# KITTITAS COUNTY

## DEPARTMENT OF PUBLIC WORKS

**TO:** All Staff  
**FROM:** Public Works Plan Review Team  
**DATE:** November 10, 2022  
**SUBJECT:** LPF-22-00007 Forest Ridge Phase 5 Final Plat (Round 2 Review Comments)

FOREST RIDGE - PHASE V PERFORMANCE BASED CLUSTER PLAT

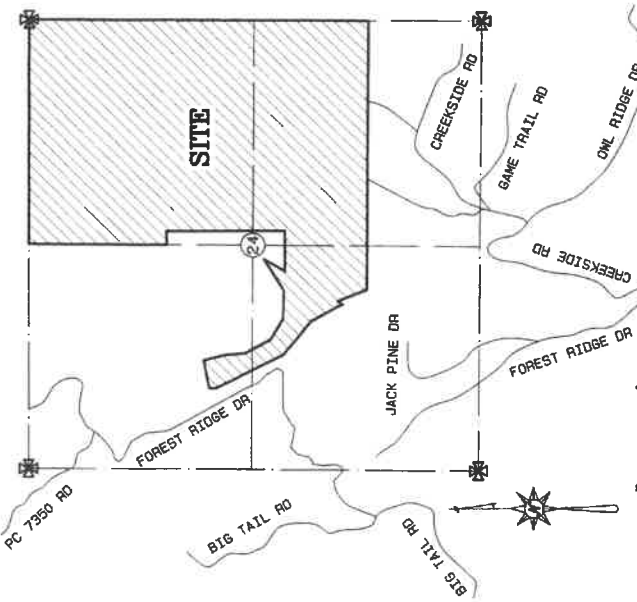
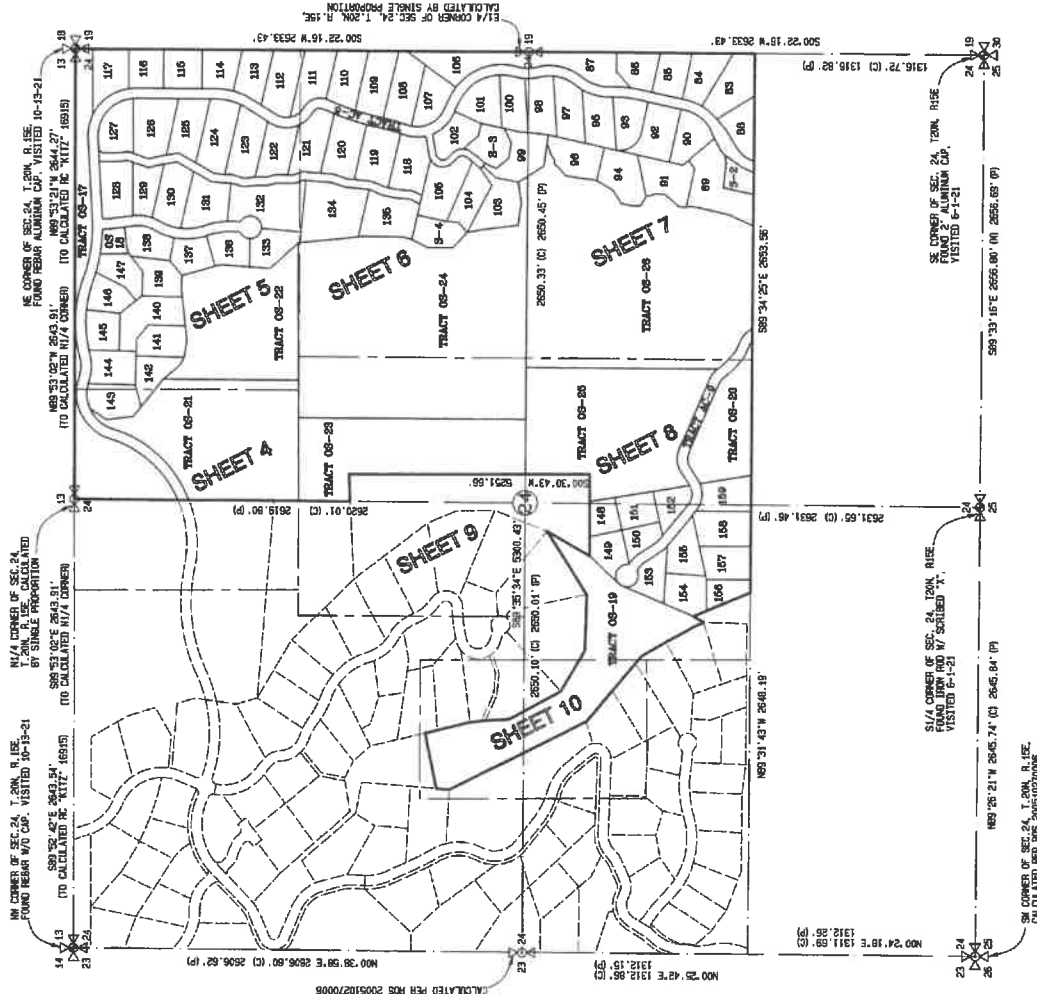
<b>SURVEY</b>	<p><b>Sheet 1:</b></p> <ol style="list-style-type: none"> <li>1. Please include Engineer (name or firm) of Record with the owner and parcel information.</li> <li>2. In the recording certificate, change “Book___ of Surveys” to “Book___ of Plats”.</li> </ol> <p><b>Sheet 2:</b></p> <ol style="list-style-type: none"> <li>3. Include labels for adjacent plats with recording numbers (EX: Plat Bk:10, Pg.4)</li> <li>4. Under existing legal description, change “Recorded of said County” to “Records of said County” (3 occurrences)</li> <li>5. In the Legend Change “Forest Ridge-Phase III” to “Record Info per Forest Ridge-Phase III”</li> <li>6. The South line of SW 1/4 of Section shows a record distance that does not match the reference (.84 vs .80)</li> <li>7. The two calculated section corners that are also property corners will need to be set and shown on the face of the plat.</li> </ol> <p><b>Sheet 4:</b></p> <ol style="list-style-type: none"> <li>8. Lot Closure report calls out a distance of 0.36 feet near the N1/4 corner of section, which is not shown on the plat. This corner will also need to be set.</li> <li>9. Show all easements as “Existing”, “Herein Dedicated”, or “Created by Separate Document” (or similar language).</li> <li>10. The area containing Tags L1, L2, C3 and C1 would benefit from a detail window (not required).</li> <li>11. Show the total Width of Tract AC-10.</li> <li>12. Identify the dashed lines on either side of Stream E and F.</li> </ol> <p><b>Sheet 6:</b></p> <ol style="list-style-type: none"> <li>13. The Calculated East 1/4 corner of Section will need to be set.</li> </ol> <p><b>Sheet 7:</b></p> <ol style="list-style-type: none"> <li>14. The area Curve Tag C102 would benefit from a detail window (not required). If a detail window is not used, “tick marks” or “crows feet” identifying the ends of the 197.26 long line would clarify things.</li> <li>15. Spelling typo near Eastmost corner of Tract S-2 “ROW VARIES”</li> </ol>
